MOD 4 - EASTLAKES SHOPPING CENTRE - RESPONSE TO KEY ISSUES

This letter has been prepared by Urbis on behalf of Crown Group (**Proponent**). The purpose of this letter is to set out the Proponent's response to the queries raised by the Department of Planning, Industry and Environment (**DPIE**) in a Key Issues Letter dated 7 January 2020 and other matters raised by State Government authorities.

2 GARDENERS ROAD BOUNDARY PLANTERS
1 : 50

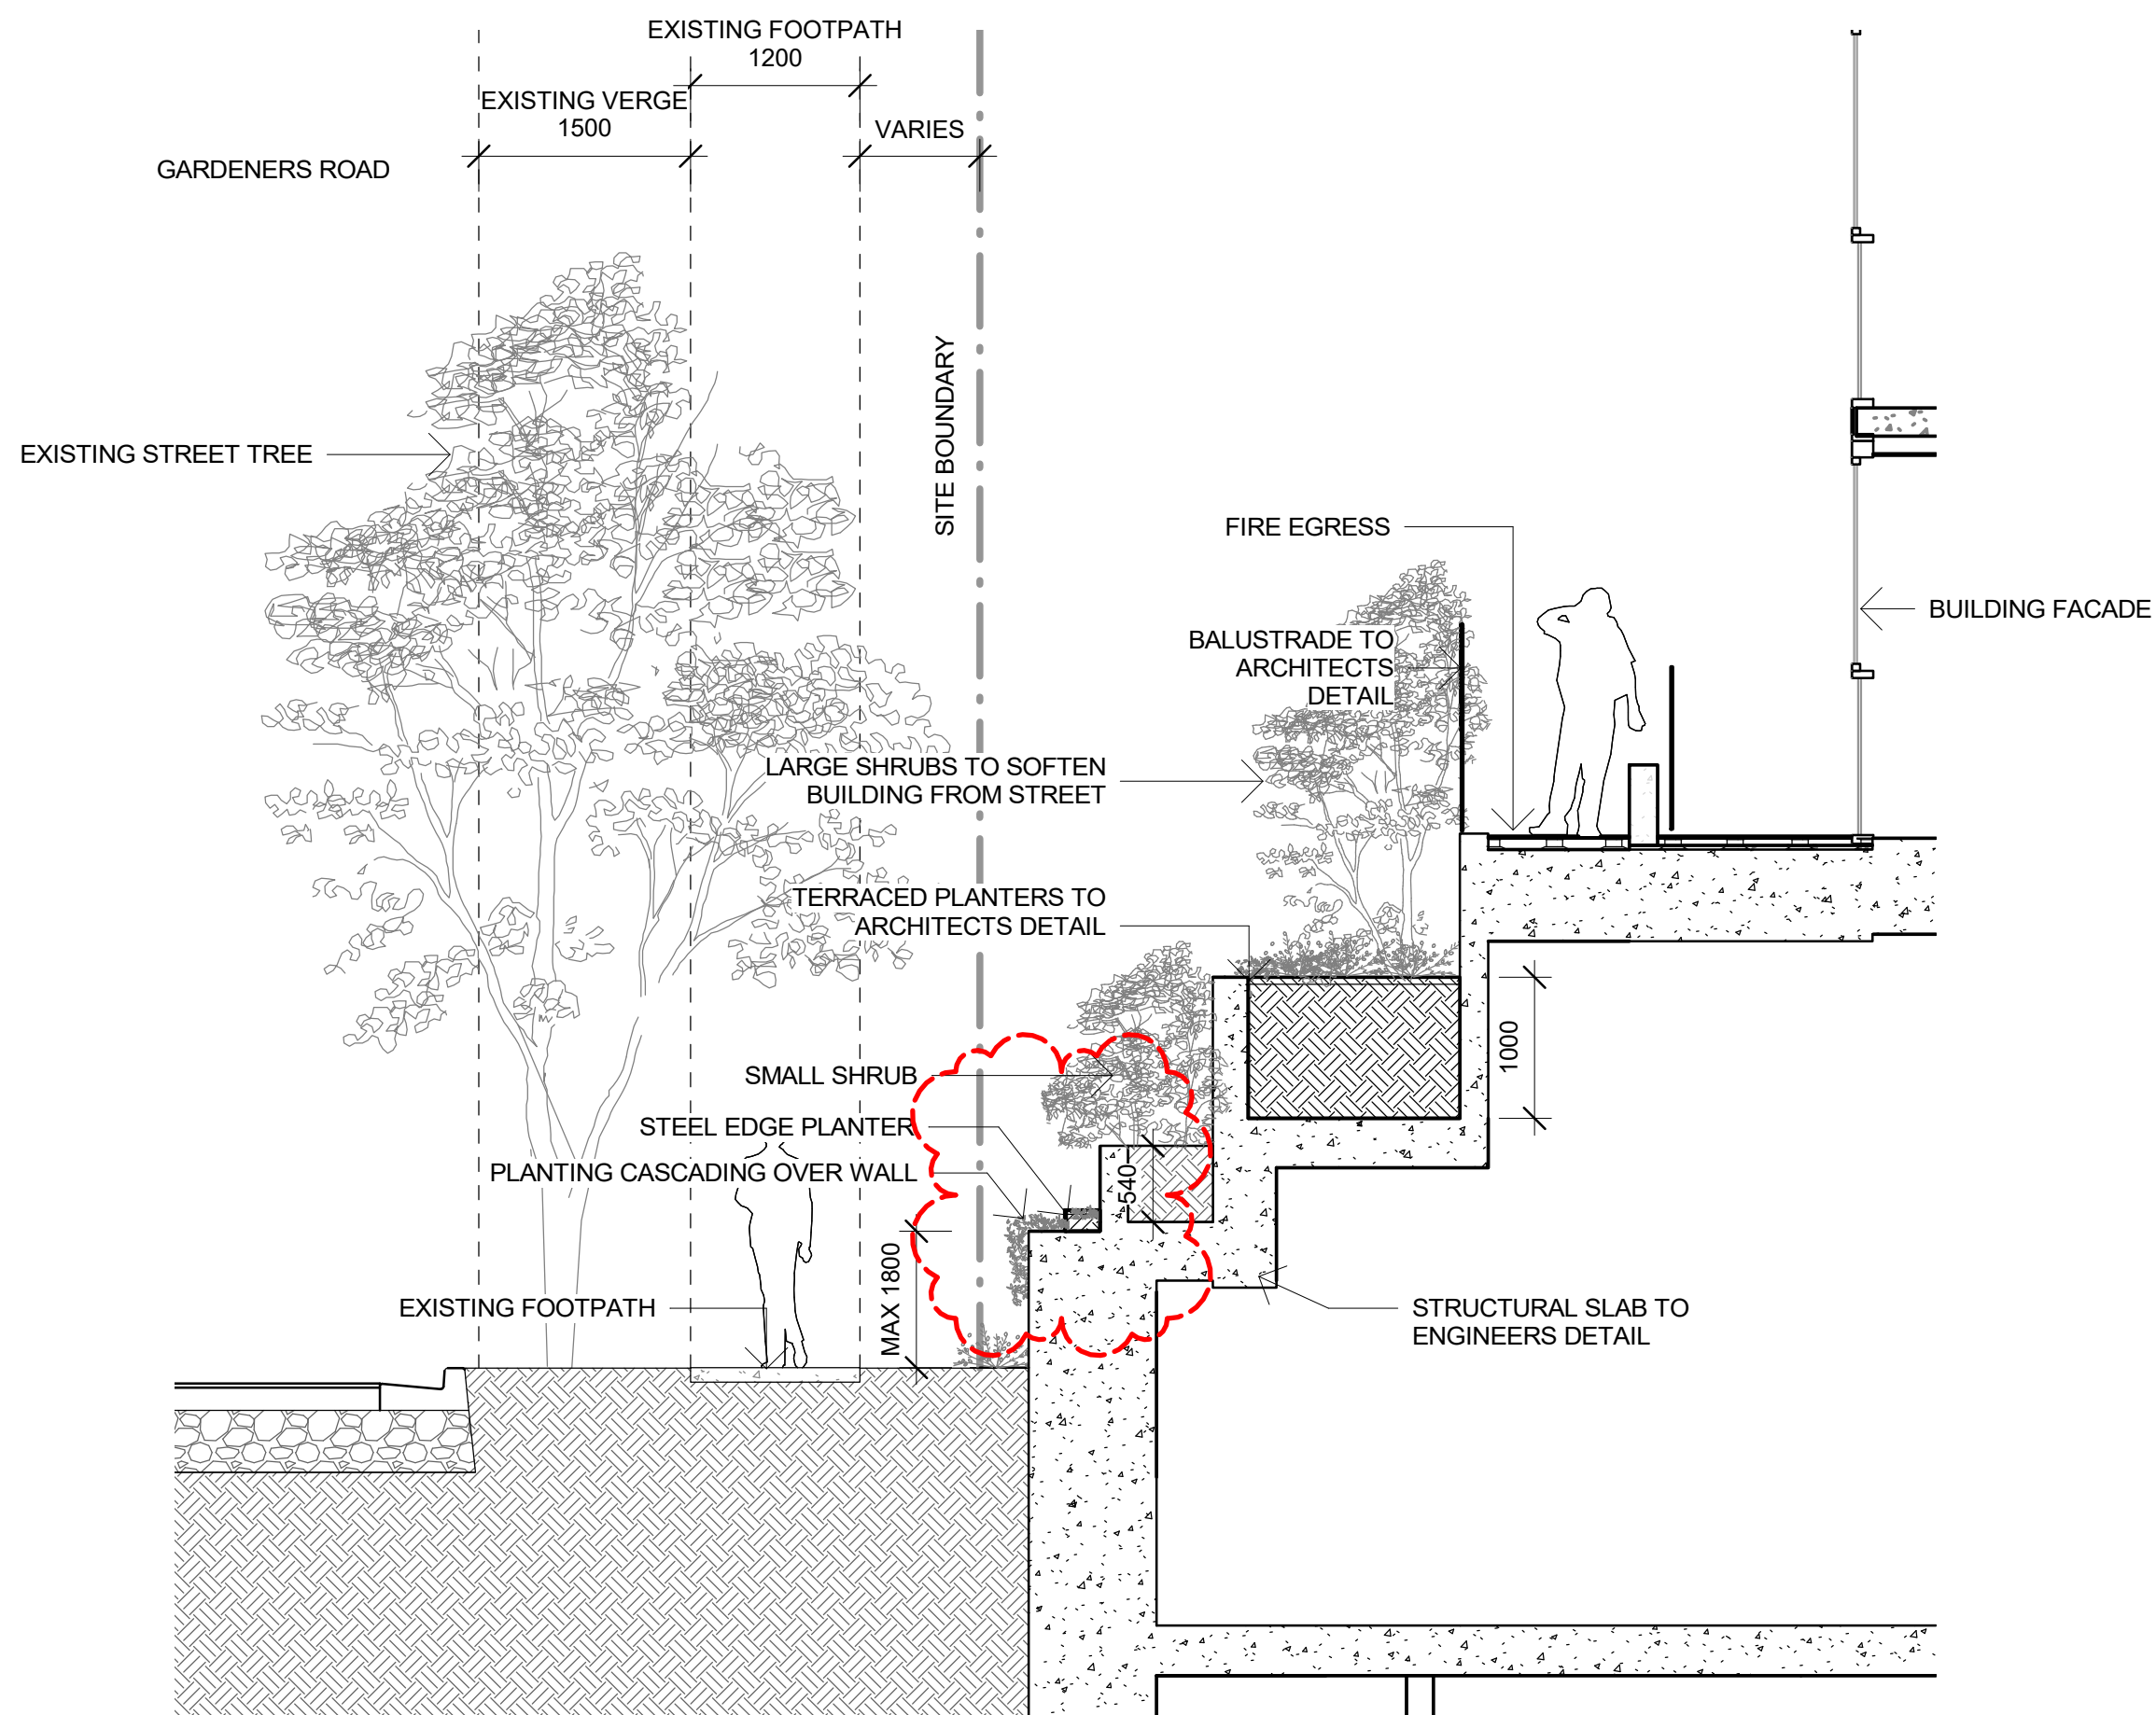
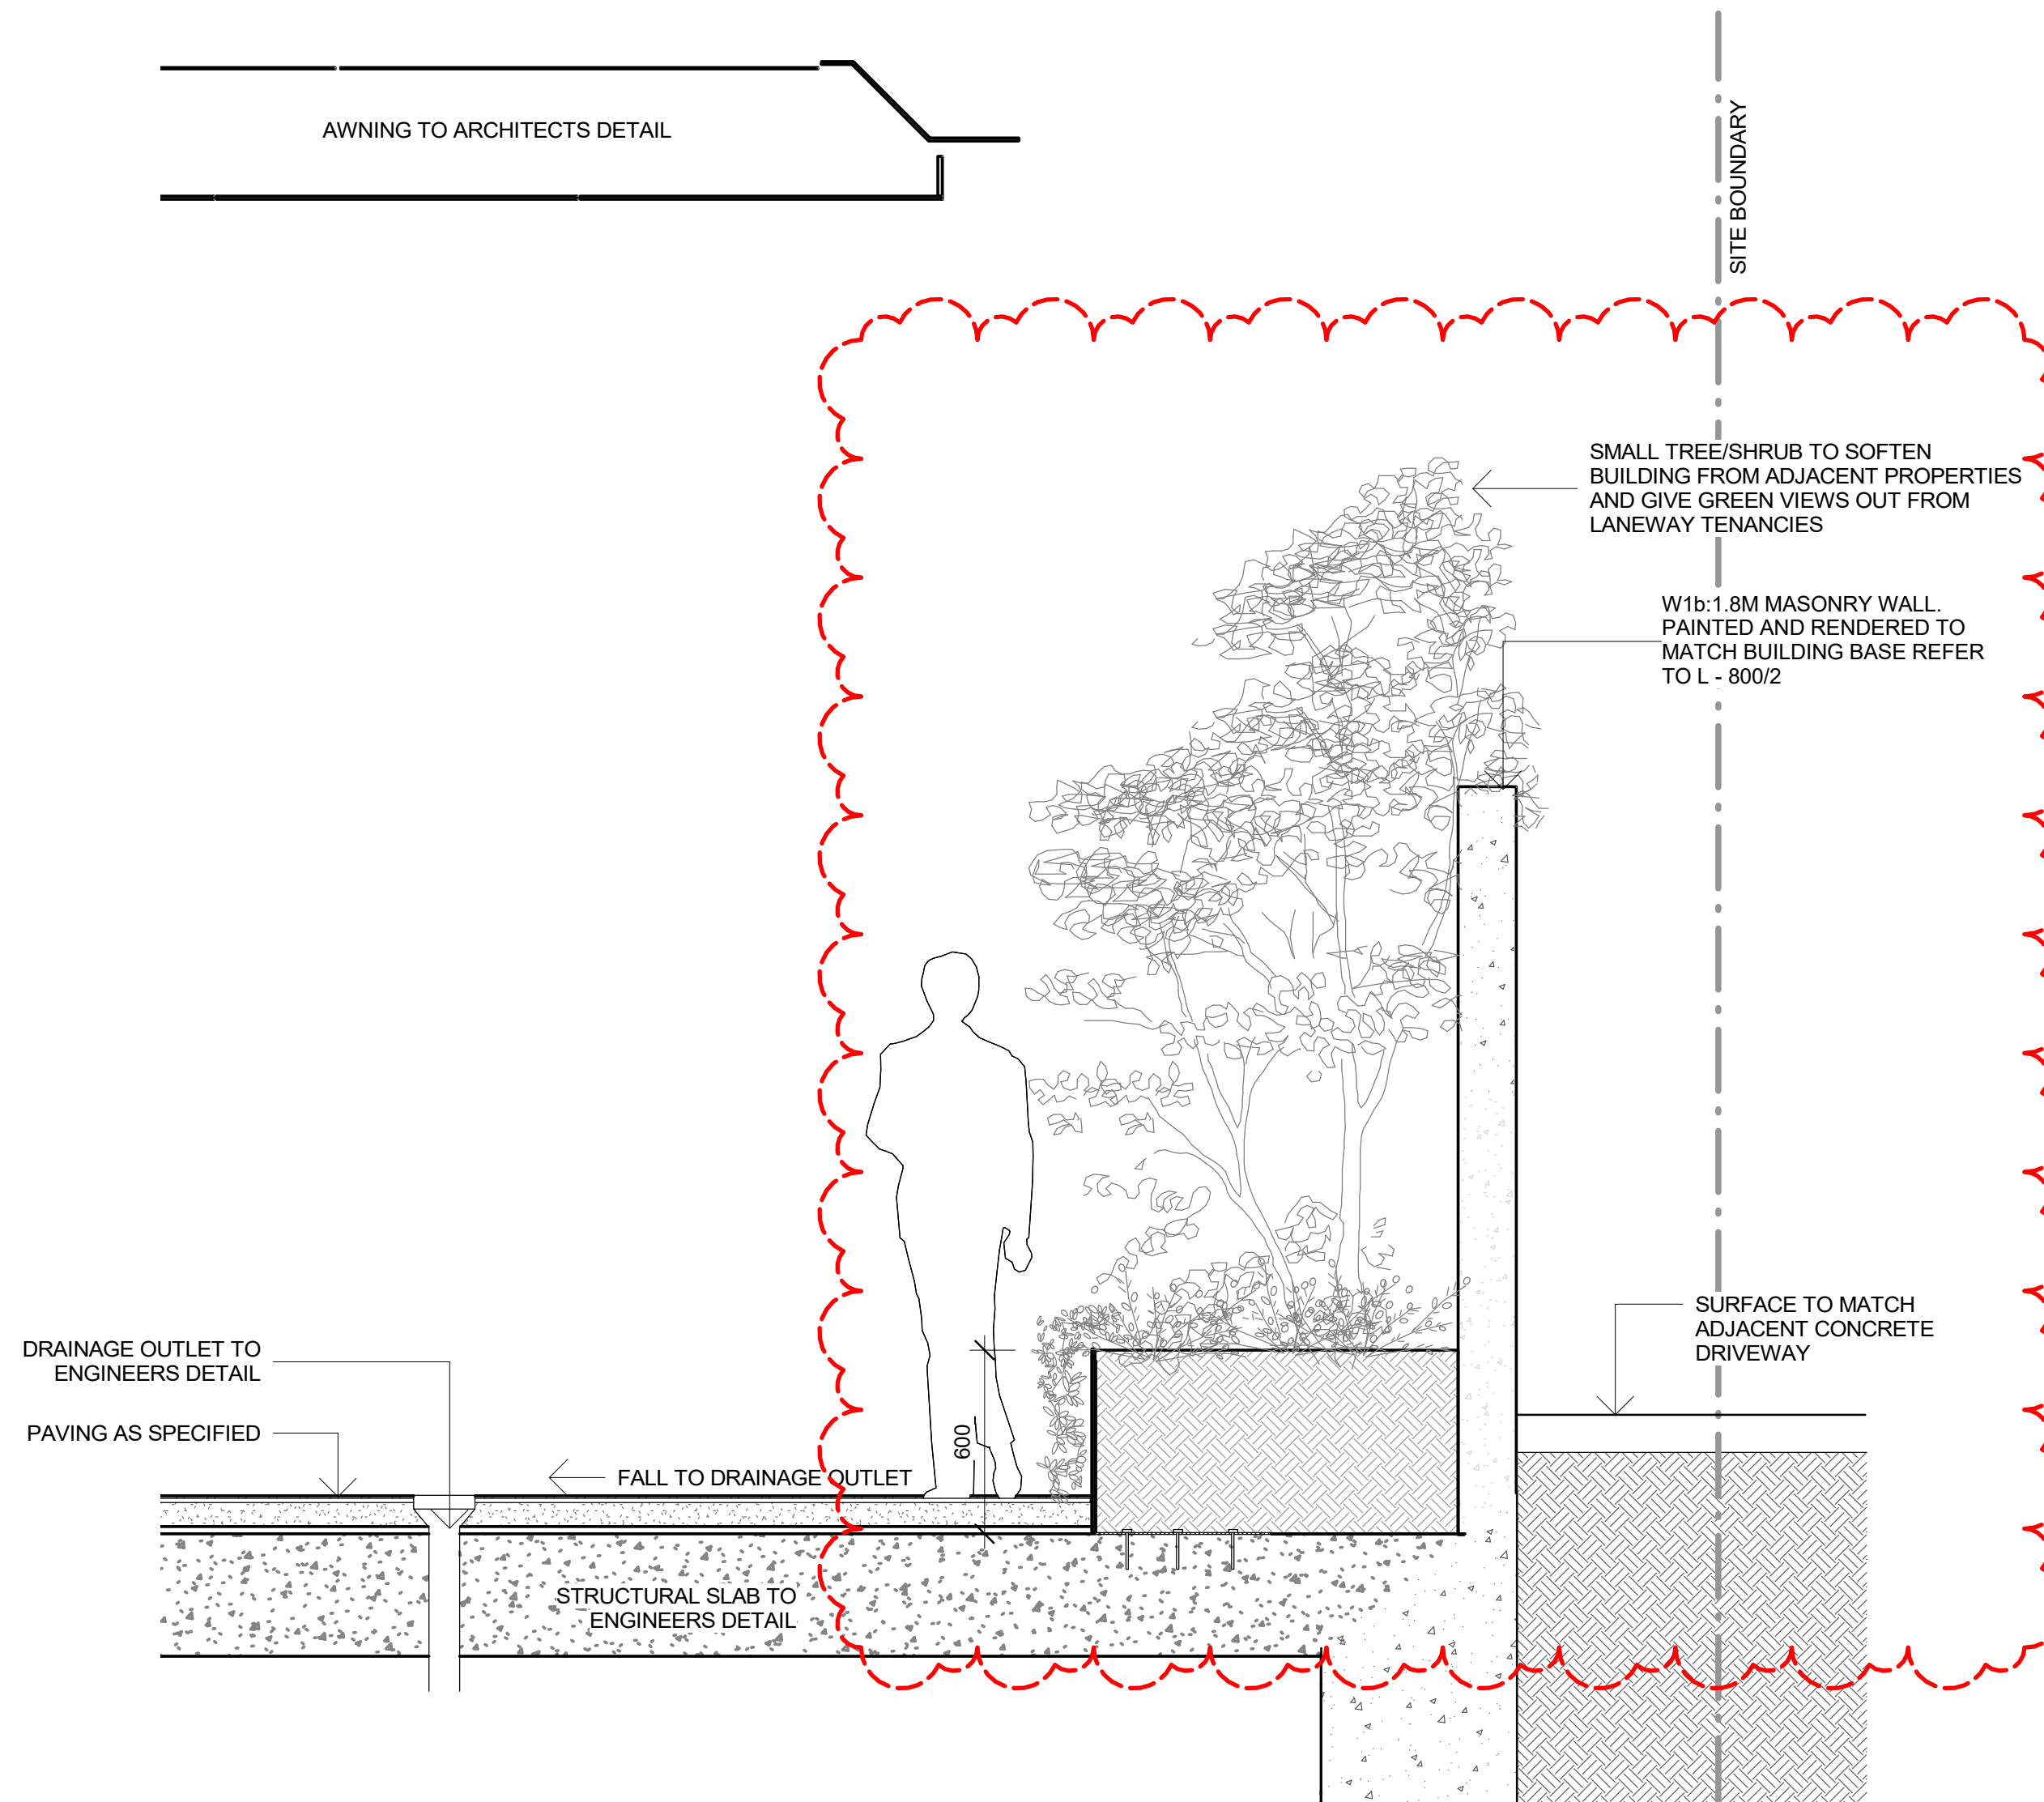
Key Issue	Response
<p>3.4 The planters along the Gardeners Road frontage appear too narrow and will not provide adequate space for tree and shrub planting consistent with the approval of MOD 1, resulting in adverse outcomes for the streetscape. Plans should be amended to ensure a similar or better landscaping outcome compared with the approved scheme, including trees to a mature height of at least 10 metres along the eastern half of the frontage, an upper level of planters with a mature height of at least 5 metres along the western half of the frontage and a lower level of plantings to a height of at least 1.8 metres along the lower half of the western end of the frontage.</p>	<p>In response to DPIE's issues, modifications are proposed to the design of the Gardeners Road planter and are illustrated in the Landscape Plans prepared by Turf Design Studio and submitted at Appendix C.</p> <p>In summary, the planter along Gardeners Road has been modified to contain sufficient soil volume for five trees with a mature height of 10m at the eastern end and five trees with a mature height of 5m along the western end. This has been achieved by increasing the depth of the planter box to provide soil volume for trees in accordance with the ADG.</p> <p>By lowering the base of the upper northern planter and with the connection of soil volumes, shrubs in the lower planter now have additional soil volume that will facilitate growth of 1.8m plantings.</p>

<p>3.4.1 While the sections show smaller walls and indicate a maximum height of 1.8 m as required, we do not agree with the advice in the letter that the minimum height at the boundary must be adjusted to 1.8 metres for security and safety - it is essential that the maximum height not exceed 1.8 metres as previously agreed during the assessment of Mod 1.</p>	<p>This was an error in the preliminary response submitted to DPIE. The landscape drawings showed a maximum wall height of 1.8m along Gardeners Road which is the maximum wall height proposed along this elevation. An option was being investigated to increase the wall height for safety and security reasons and to increase soil depths, but this was option was not pursued as the Applicant decided to proceed with the approach documented which achieves the required soil depths by lowering of the base of the planters. The incorrect references have been subsequently removed from this letter.</p>

<p>3.4.2 tree planting should extend across the front of the entire building, which includes reinstating the tree planting on the western most edge of the frontage. If tree planting can't be provided to the upper level planters at this location, the lower level planters must be redesigned to support tree planting instead.</p>	<p>Tree planting has now been provided along the majority of the northern frontage. This has been achieved by lowering the base of the upper level planter to achieve five x 5m trees and ten x 10m trees in accordance with the ADG soil volume guidelines. Where soil volume is not sufficient for tree planting, six shrubs to a mature height of 3m have been provided. Shrubs with a mature height of 2m have also been provided on the lower level planter.</p>
<p>3.4.3 further detail is required to show how the proposed three tier arrangement would work to provide a landscaped green edge, particularly at the lowest level</p>	<p>A detail of the shallow depth lower planter has now been provided (refer Appendix C). To ensure plant growth is sustained the lower level planter soil volume will be connected to the adjacent larger planter via seep holes as shown in the detail. These seep holes will allow moisture to come through into the lower planter and will allow roots access to the</p>

Key Issue	Response
adjoining the footpath. The drawings show planters overhanging the edge and the lowest tier at the street edge with a soil depth of 150mm, but it is unclear how this would be achieved and if this would be sufficient to support and sustain plant growth.	larger soil volume. The plant species - Jasmine has been selected for its hardiness.
